WEST SUSSEX COUNTY COUNCIL CONSULTATION

TO:	Arun District Council FAO:Michael Eastman
FROM:	WSCC - Highways Authority
DATE:	9 December 2019
LOCATION:	Land between the A259 Worthing Road and East Street/Fitzalan Littlehampton BN17 7PP
SUBJECT:	LU/340/19/DOC Approval of details reserved by condition imposed under reference LU/63/11 relating to Condition Nos 4 - Construction Management Plan and 5 - vehicle cleaning facilities.
DATE OF SITE VISIT:	Meeting at WSCC on the 3rd December 2019
RECOMMENDATION:	Advice
S106 CONTRIBUTION TOTAL:	n/a

WSCC in its role of Local Highway Authority (LHA) has previously requested further additional areas of information from the applicant on their Construction Environmental Management Plan (CEMP). The latest CEMP revision C has now been provided by the applicant. In italics are the points previously requested by the LHA and the LHA's confirmation that these areas have now been addressed.

MAIN SITE COMPOUNDS GA.
(TODDINGTON LANE)

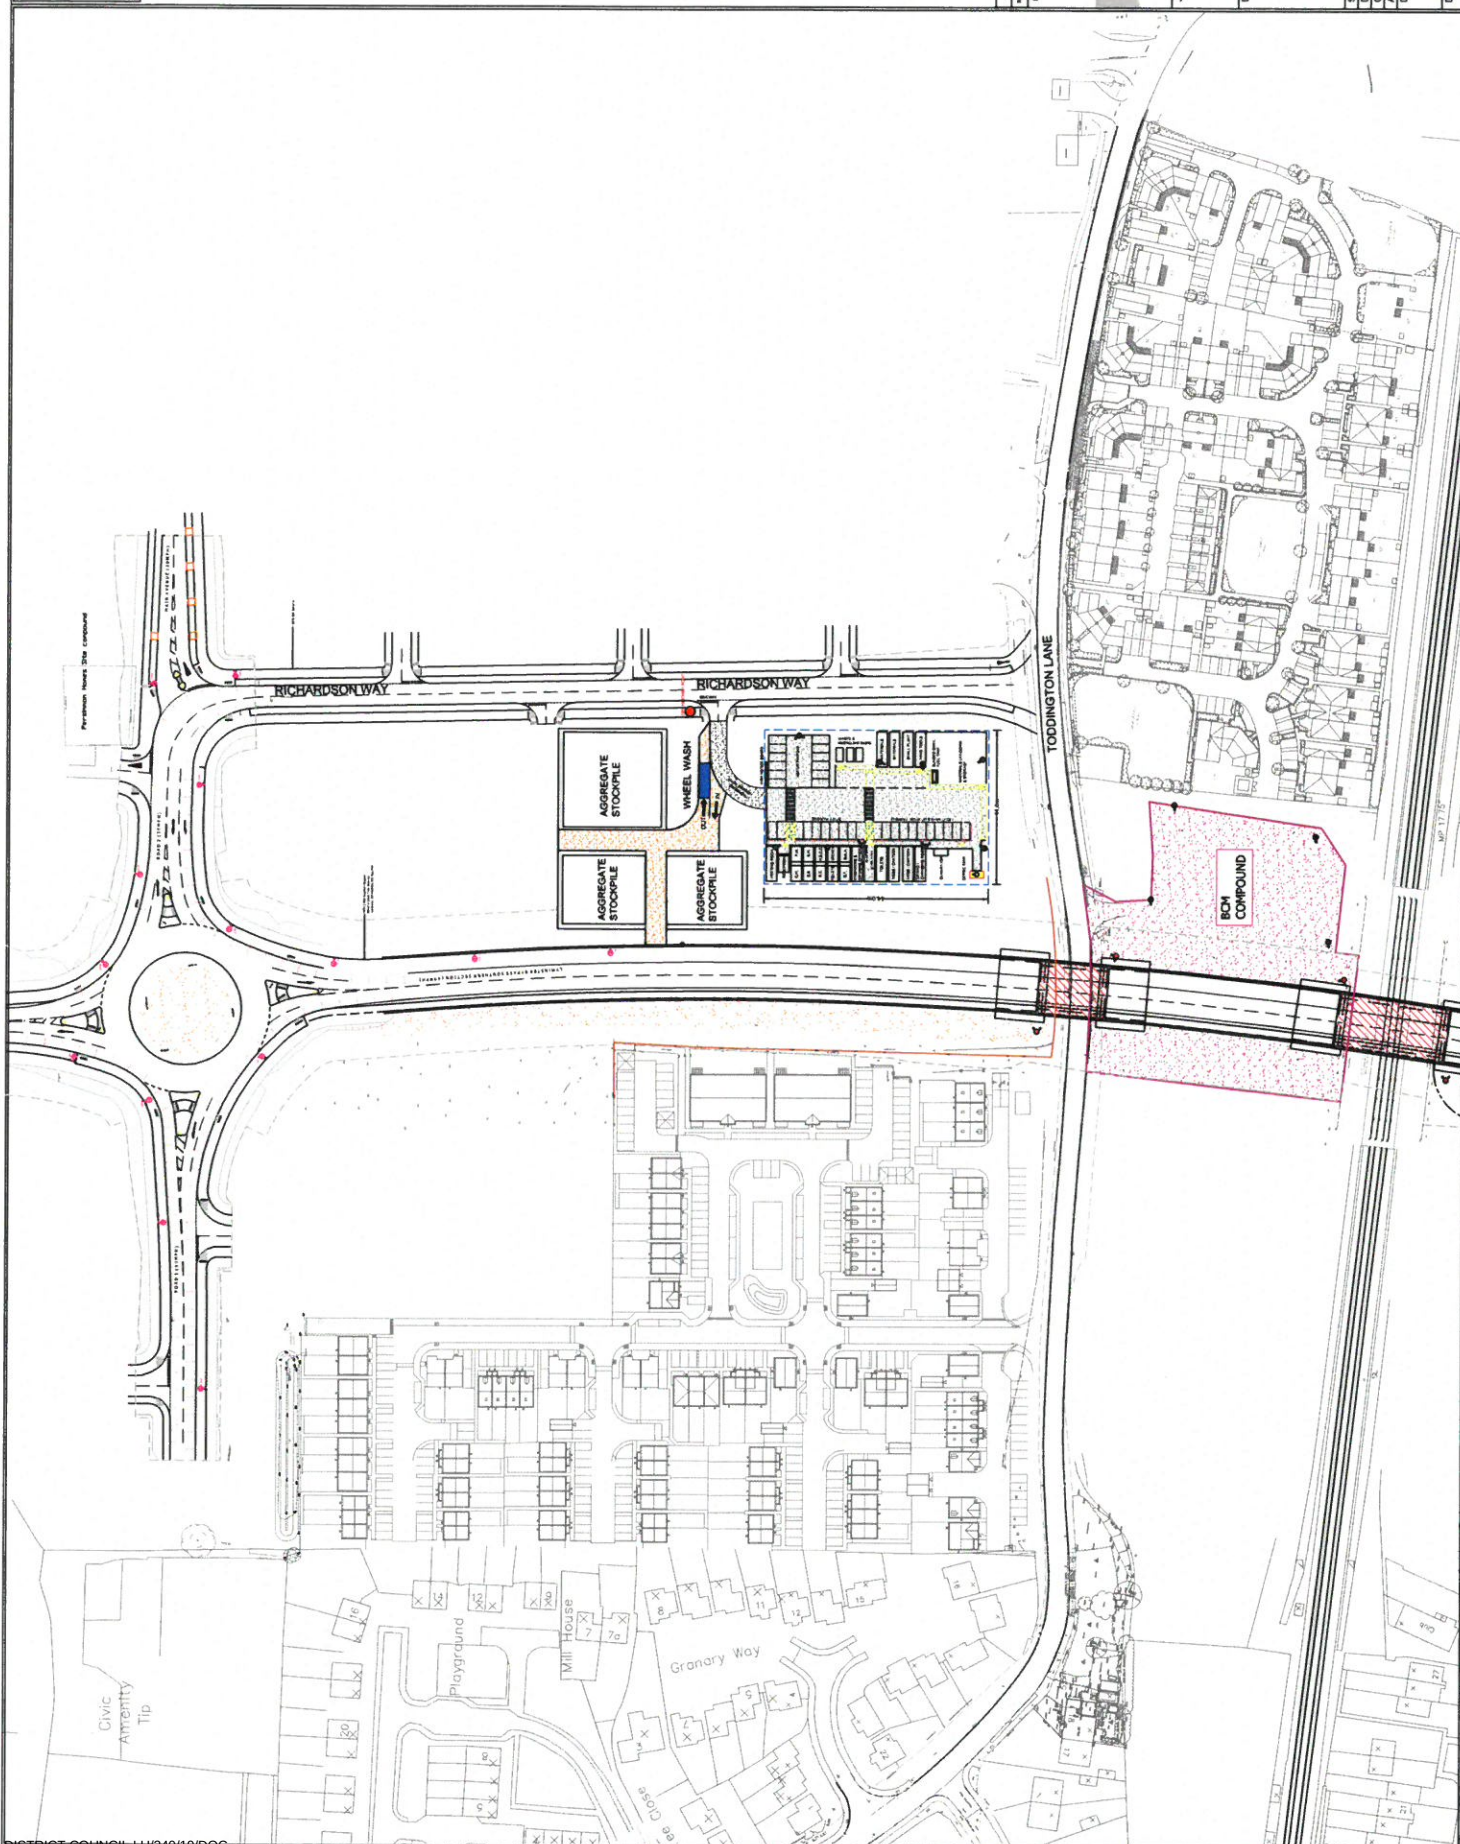
- *Parking areas have not been demonstrated i.e not shown or laid out therefore difficult to know how much contractor parking could be housed. Clarification on the level of parking and its design and layout should be provided. **Contractor parking of 40 spaces is located in the main compound off Richardson Way, the applicant has provided this in Appendix C of their CEMP.***
